Online Comment

Application H13-0160-25
Location Moulton Park High Road Moulton PE12 6PD
Proposal Installation of play equipment in picnic area & extension of public footpath

Name Diane Fairchild
Address Conservation Assistant (Tree Preservation) Planning & Development

PROPOSED FOOTPATH LAYOUT
SCALE 1:50

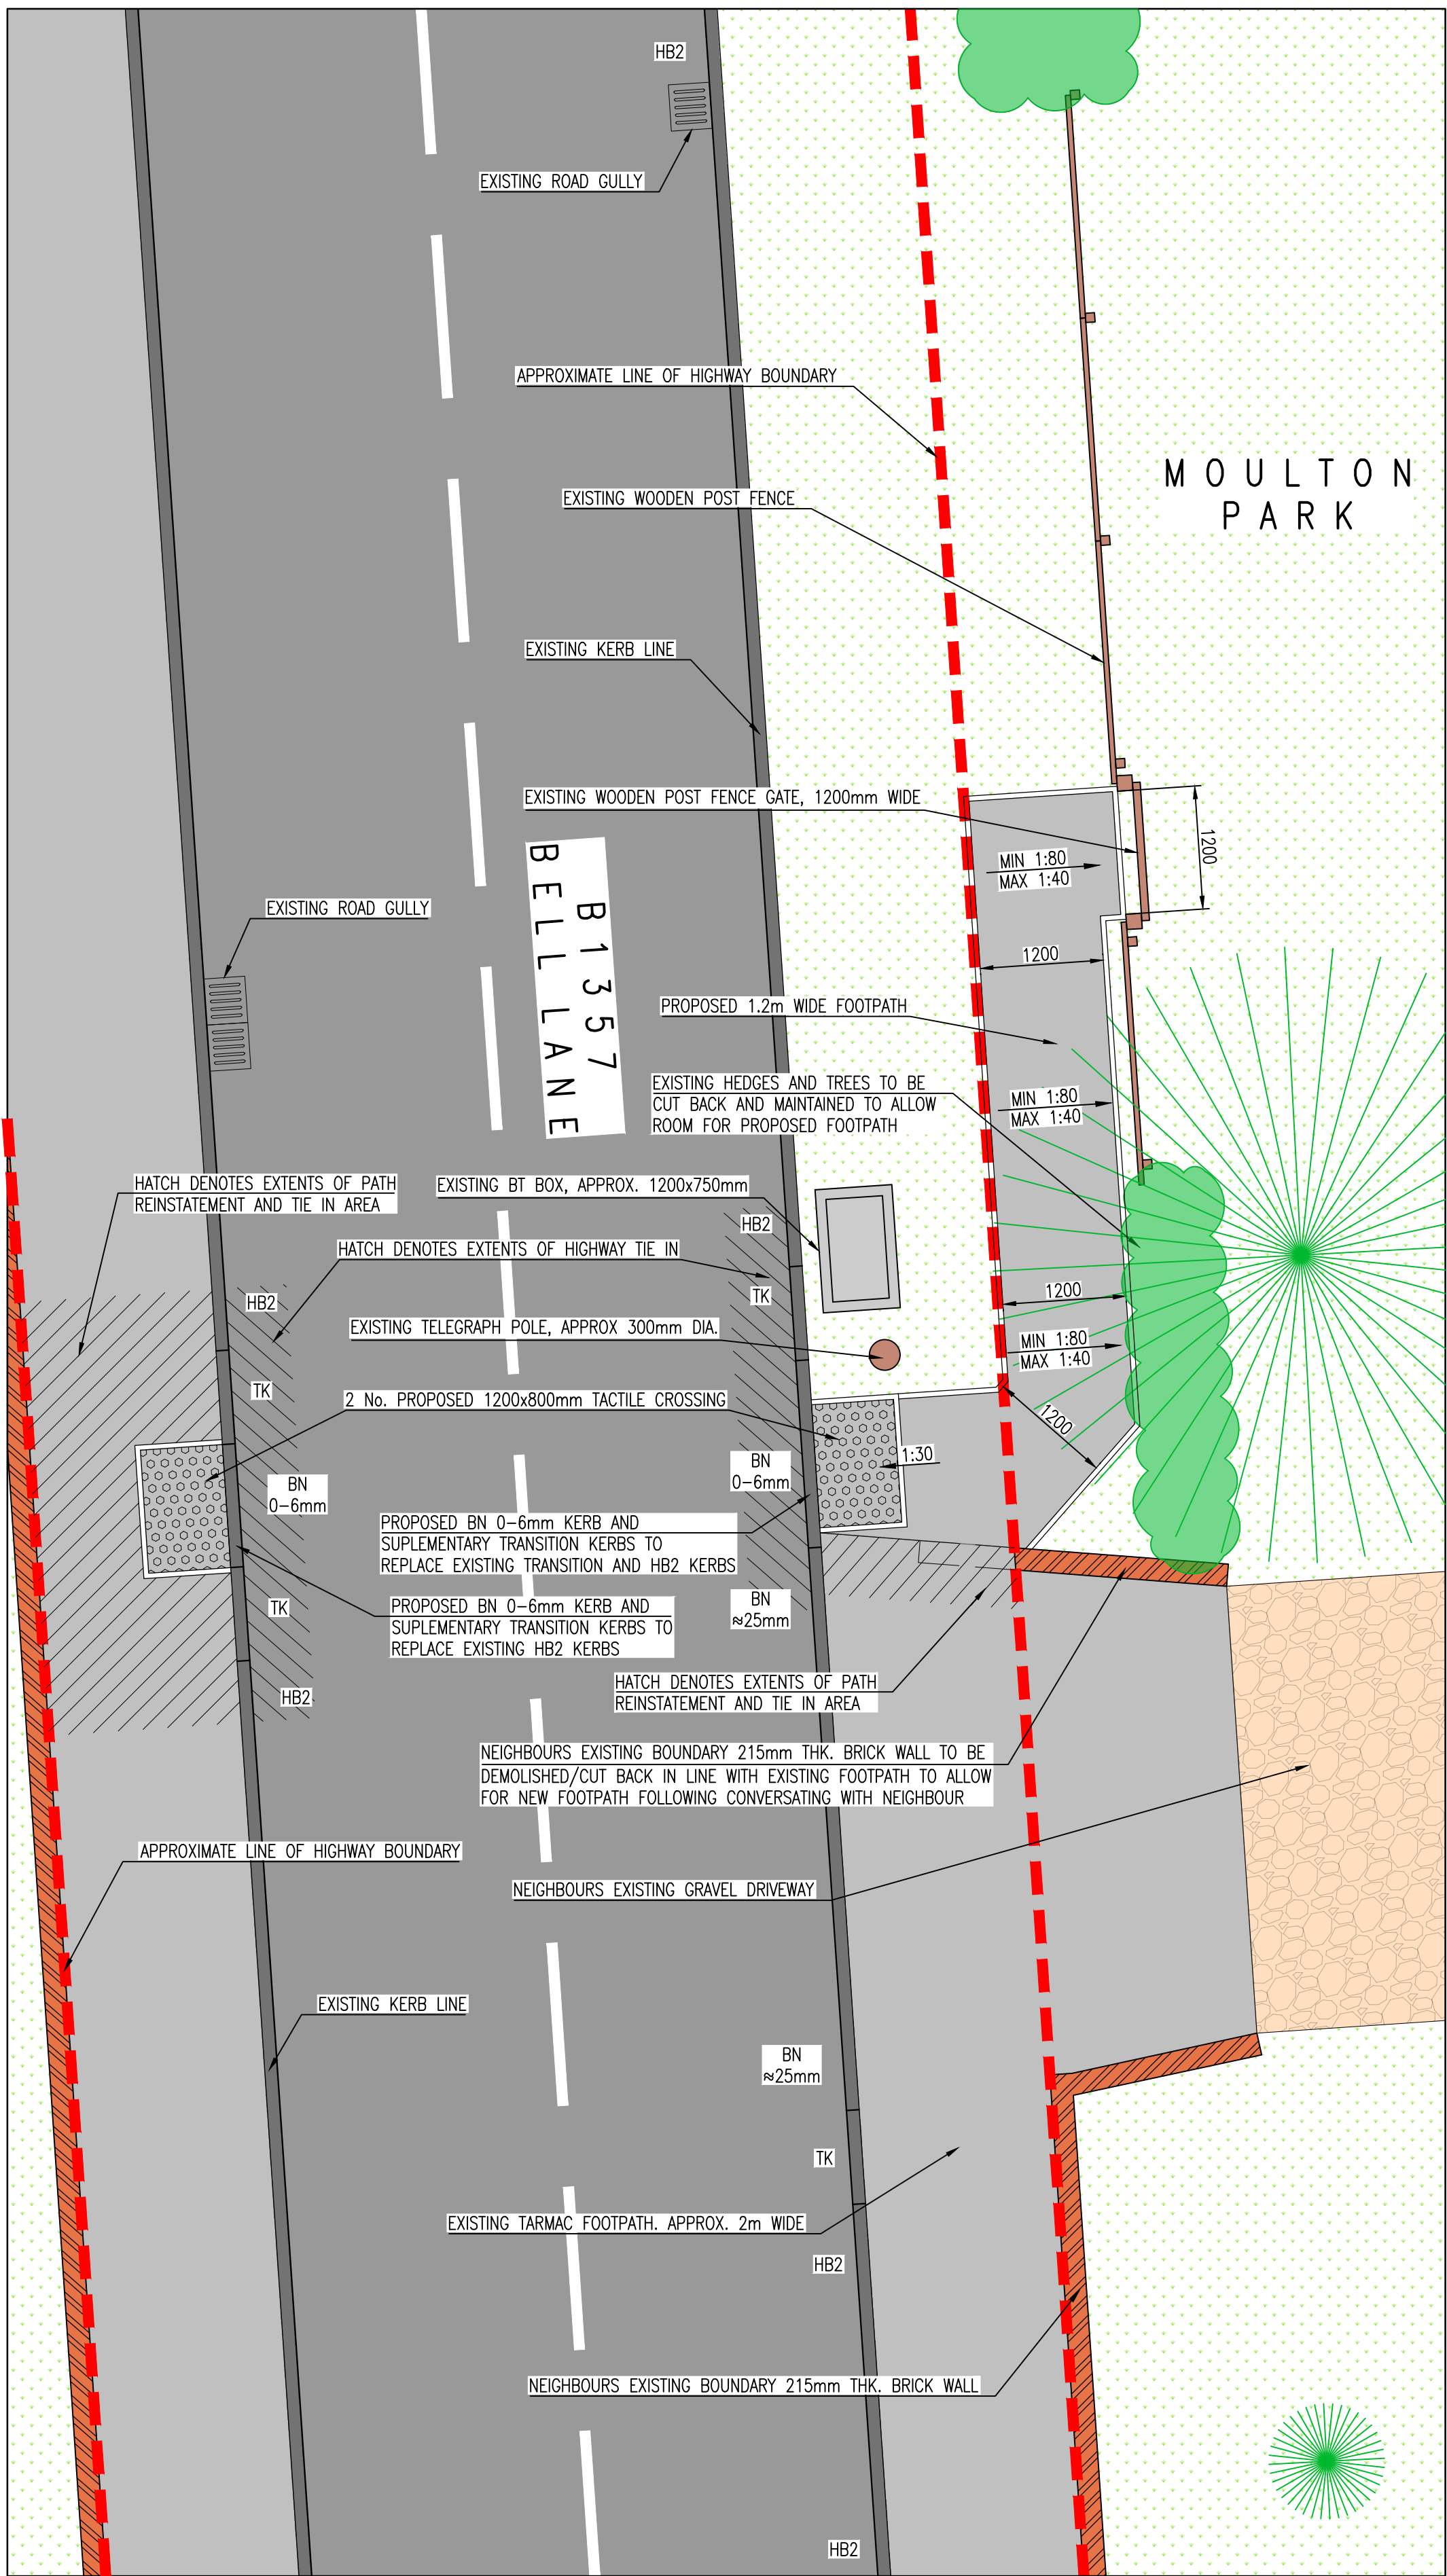
The installation of wooden gate posts (depending on what they are preserved with) are likely to cause less disturbance to any tree roots which may be nearby, than the stone piers as illustrated.
